RE: Petrogl Kiddie Academy
99999 Paseo Del Norte – SW Corner of PDN and Kimmick Dr NW
Grading and Drainage Plans
Engineer's Stamp Date: 08/05/2025
Hydrology File: C11D004A
Case # HYDR-2025-00281

Based upon the information provided in your submittal received 8/6/2025, the Grading & Drainage Plan **is not approved** for Grading Permit and Building Permit. The following comments need to be addressed for approval of the above referenced project.

GRADING PLAN 1

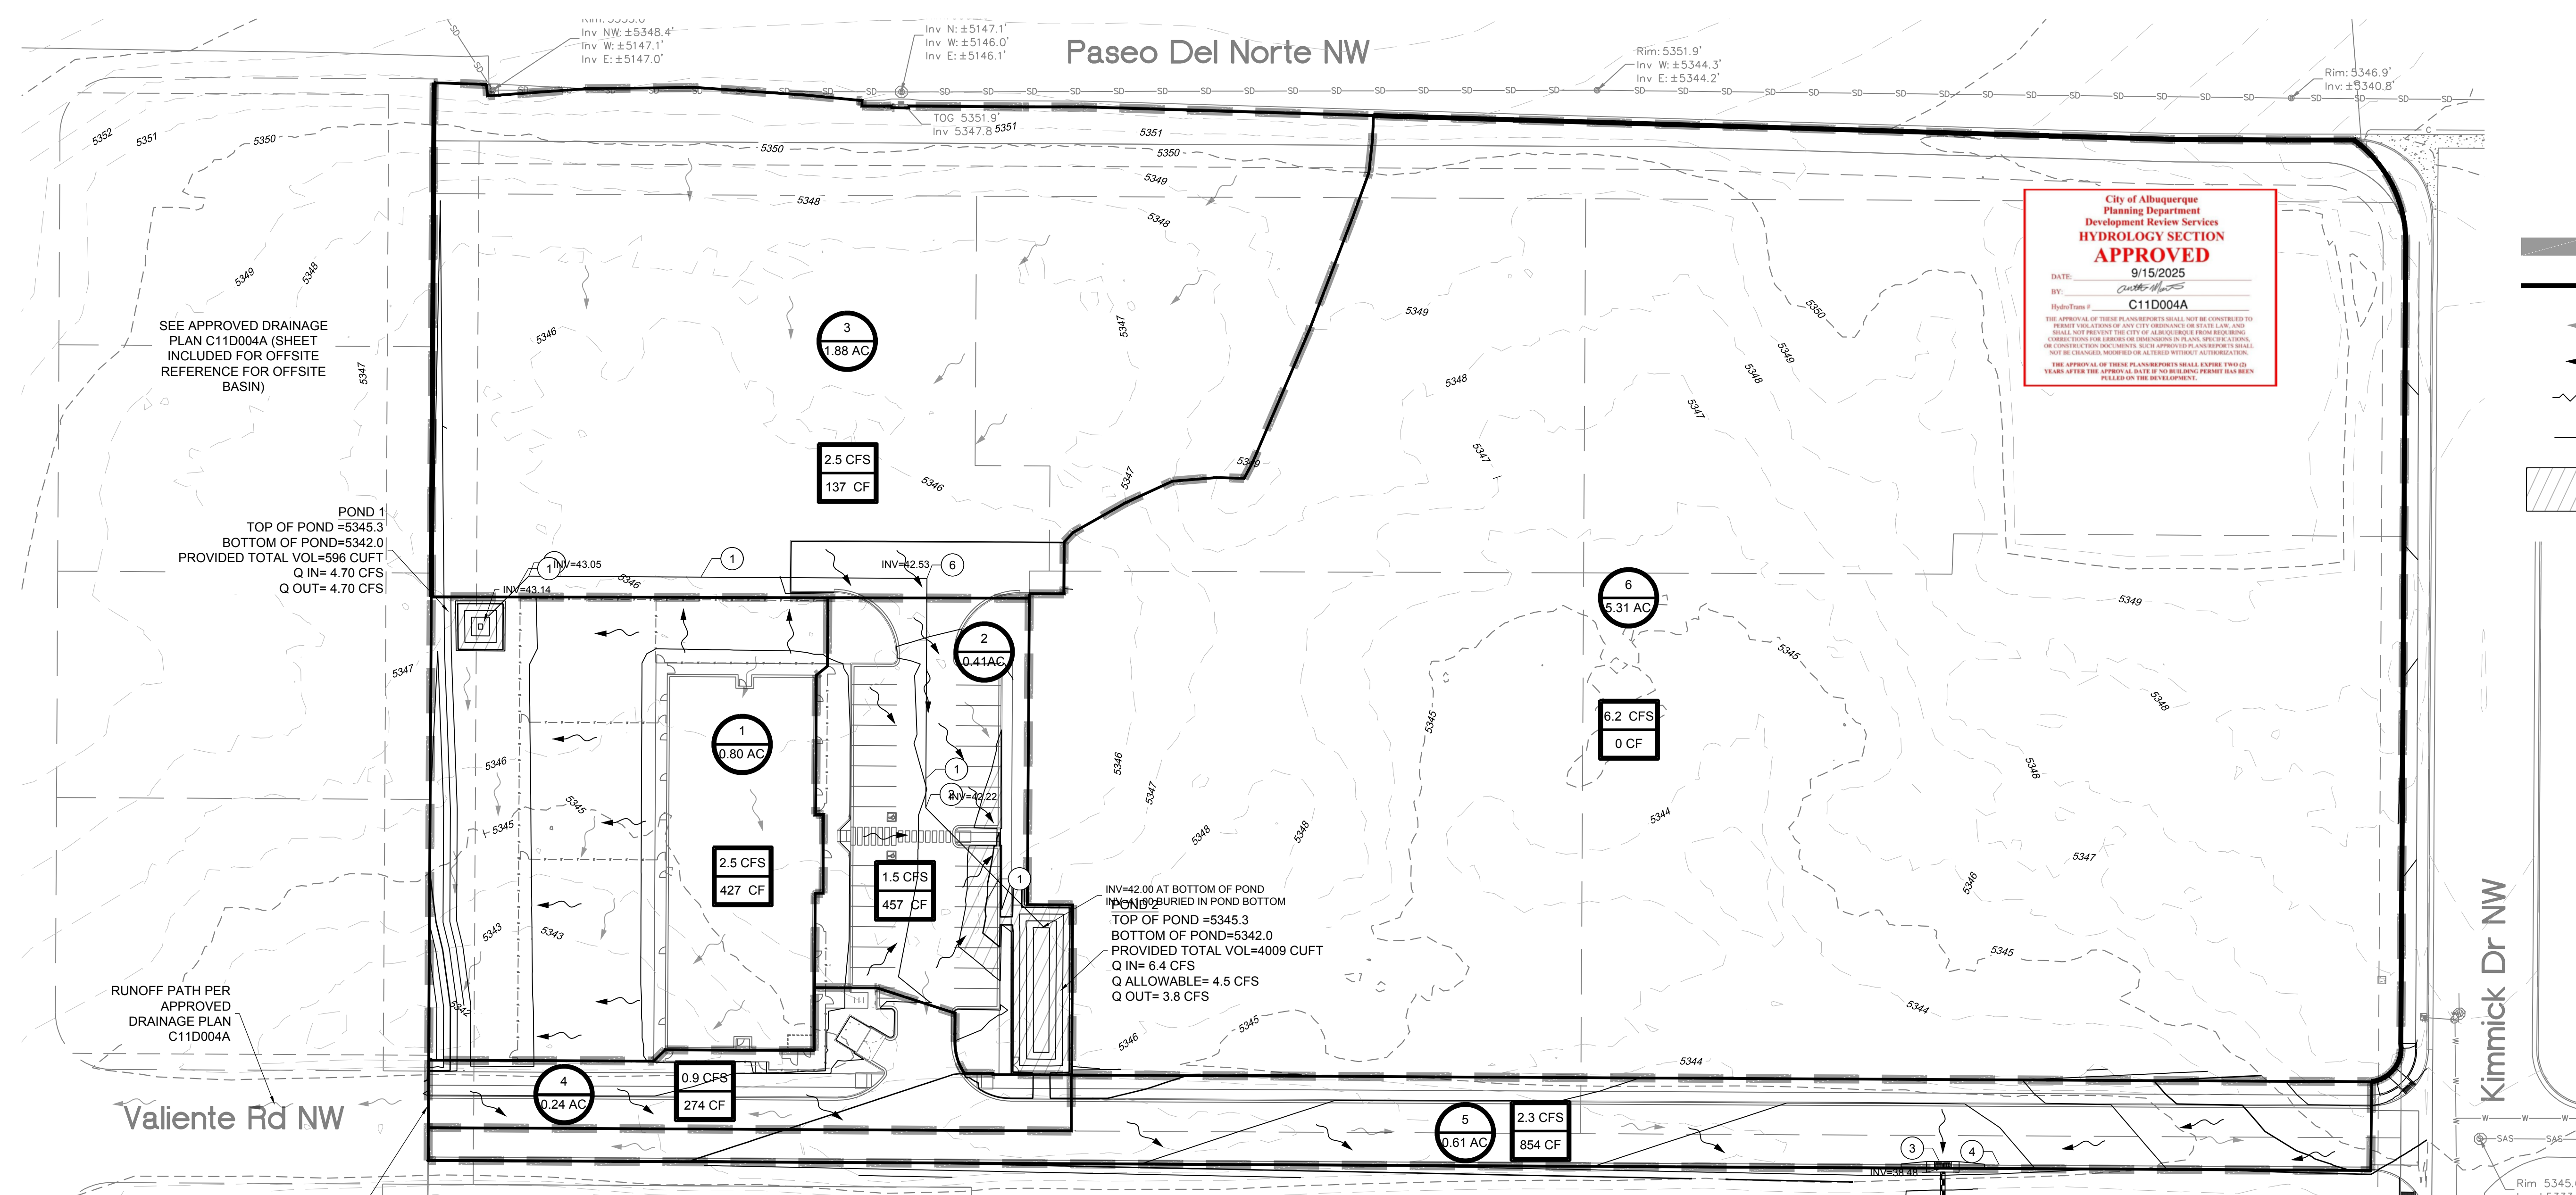
1. Sheet C-100 – There is a swale shown along the west property line that flows to Valiente Road. Stormwater discharges across the sidewalk are not allowed on collector roads and above; provide sidewalk culverts or drain lines through the curb.
2. Add the volume of the Temp Pond.
